Your ref
Our ref TL /3/2013/0271
Date 3rd May 2013

Planning application no: 3/2013/0271
Proposal: Erection of two detached dwellings.
Location: Land at George Lane Read Lancashire.

Client JWPC		
Job Title Proposed development to Land at George Street Read		
Drawing Title Proposed Site Plan		
Scale 1:200@A1	Date August 2013	Drawn J Bowden

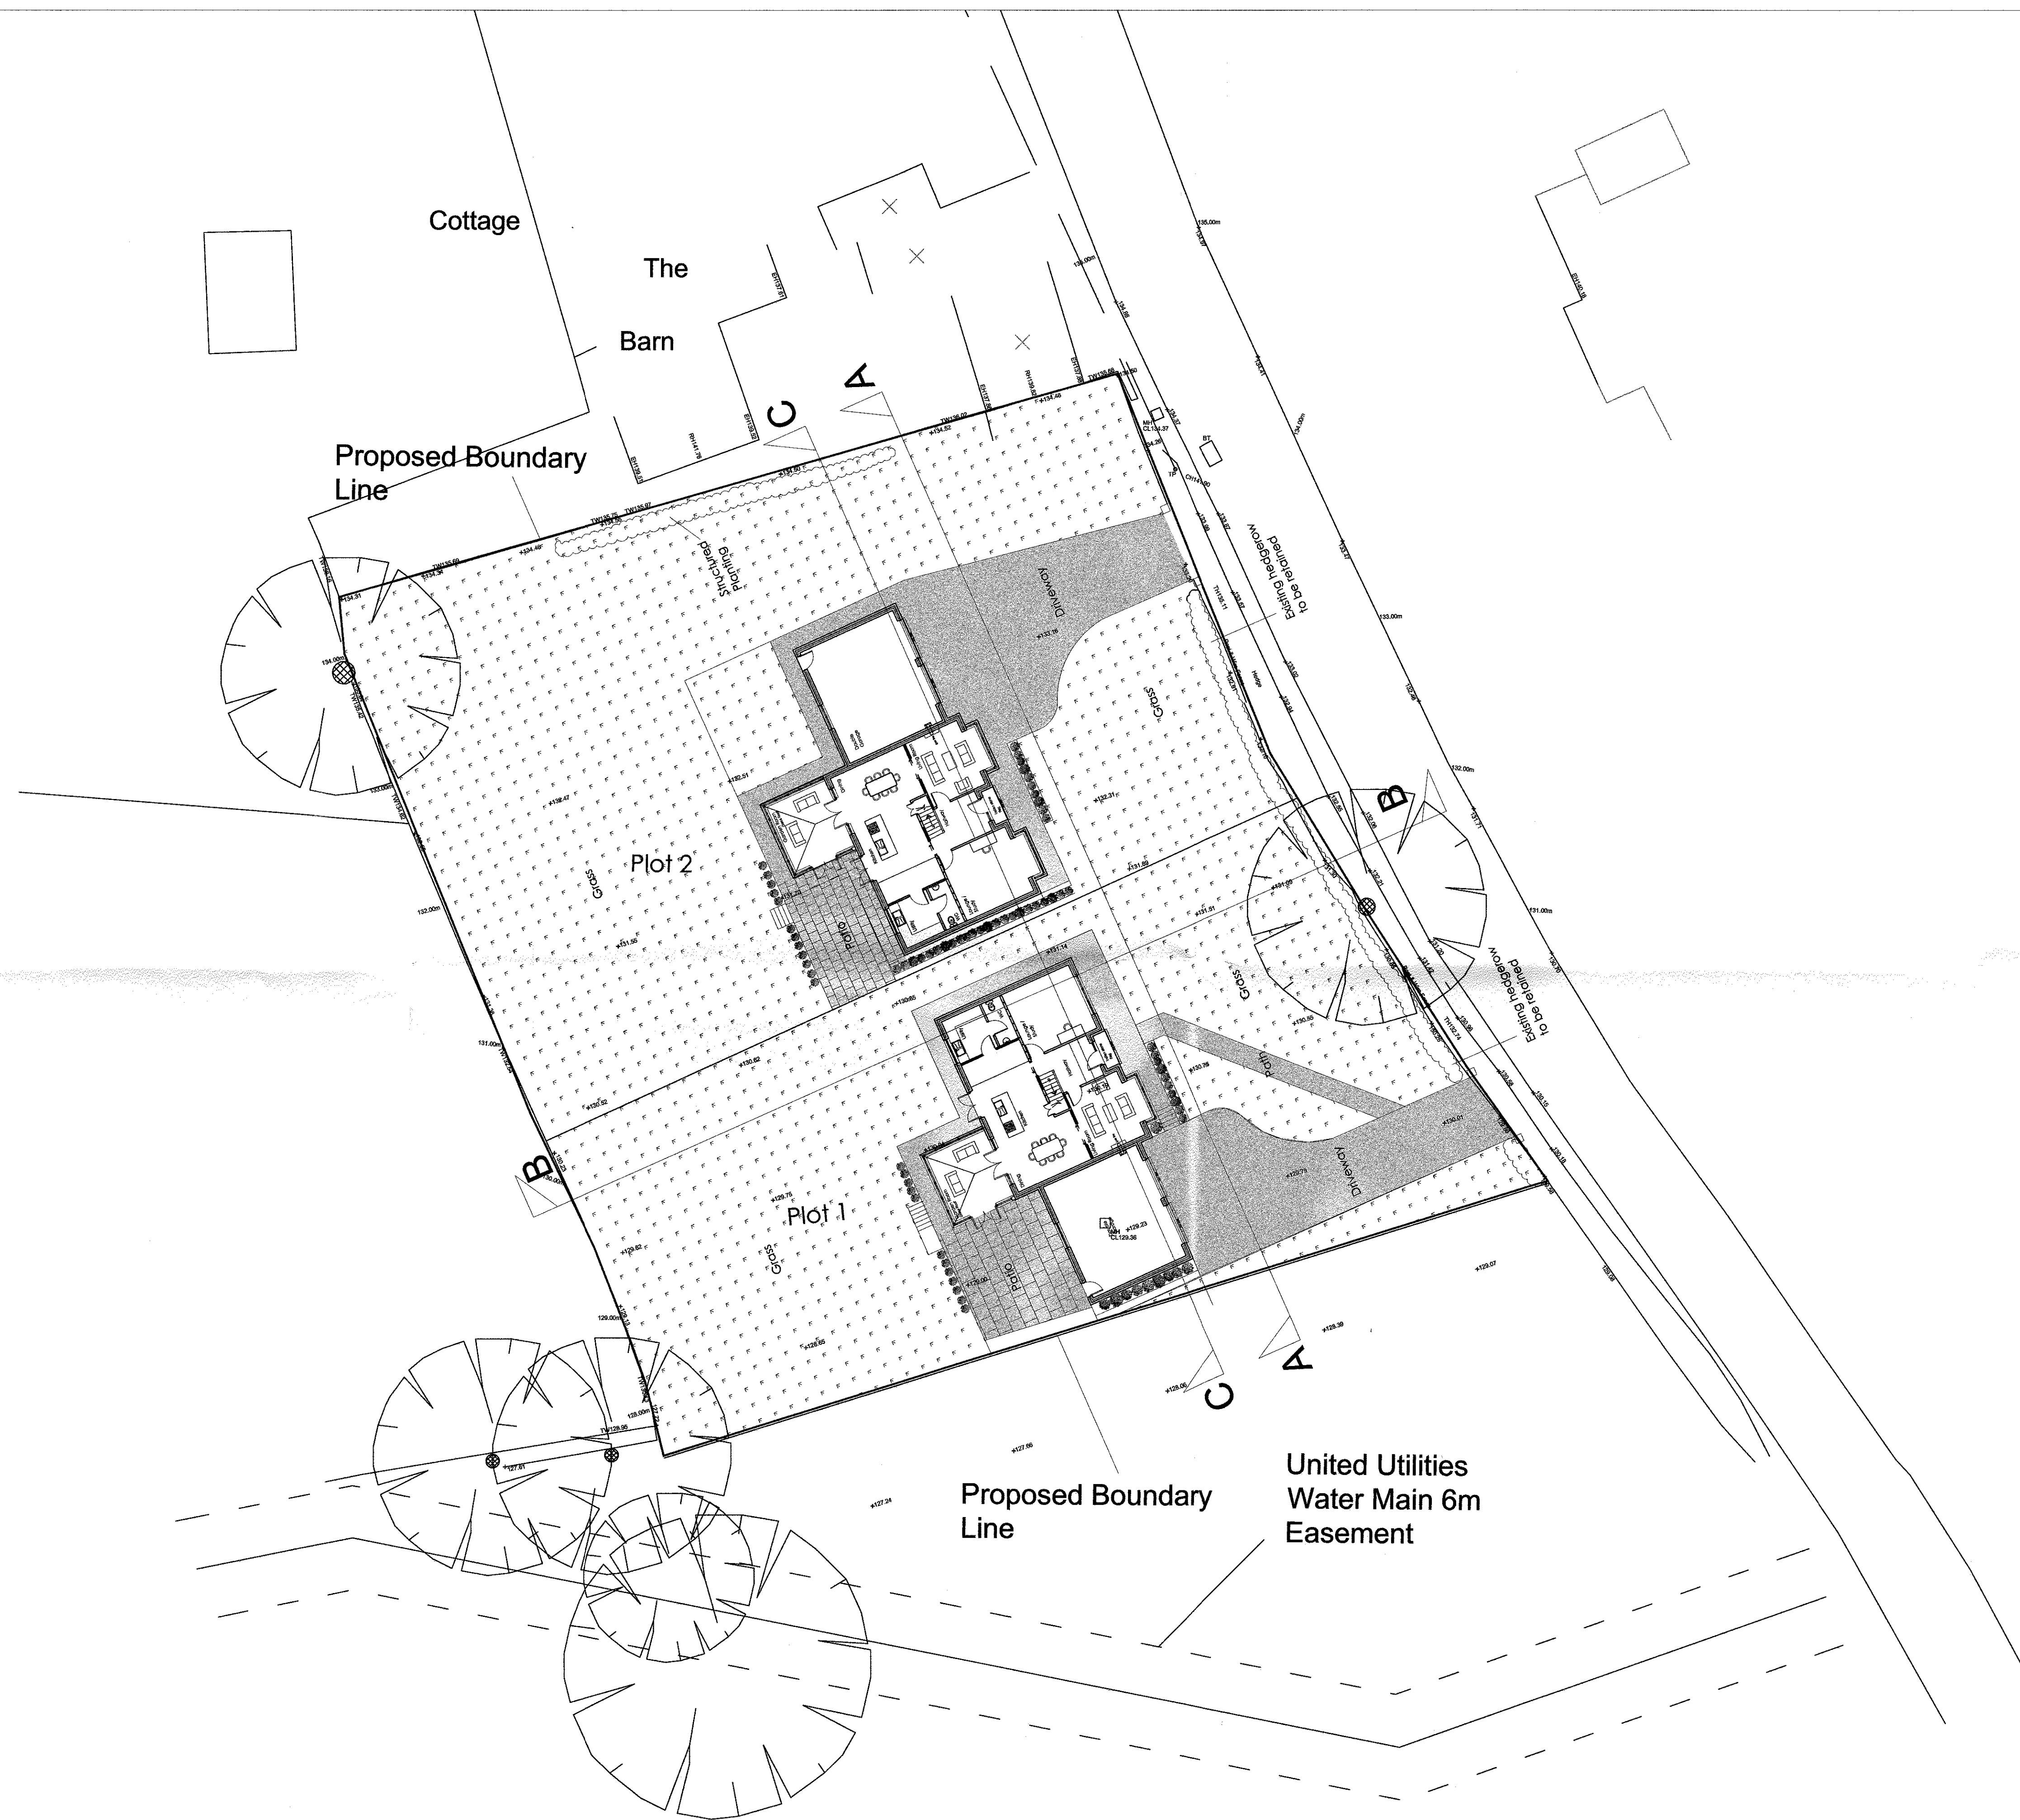
Works will be required in the highway to create the access to the site. The developer should contact LCC Highways to discuss these items and agree the works required.

Notwithstanding the provisions of the Town and Country Planning (General Permitted Development) Order 1995 there shall not at any time in connection with the development hereby permitted be erected or planted or allowed to remain upon the land hereinafter defined any building, wall, fence, hedge, tree, shrub or other device.

For each dwelling, the visibility splays to be the subject of this condition shall be that land in front of a line drawn from a point 2.4m measured along the centre line of the proposed access from the continuation of the nearer edge of the carriageway of George Lane to a point measured 45m along the nearer edge of the carriageway of Geoerge Lane from the centre line of the access, and shall be constructed and maintained at footway/verge level in accordance with a scheme to be agreed by the Local Planning Authority in conjunction with the Highway Authority. Reason: To ensure adequate visibility at the street junction or site access.
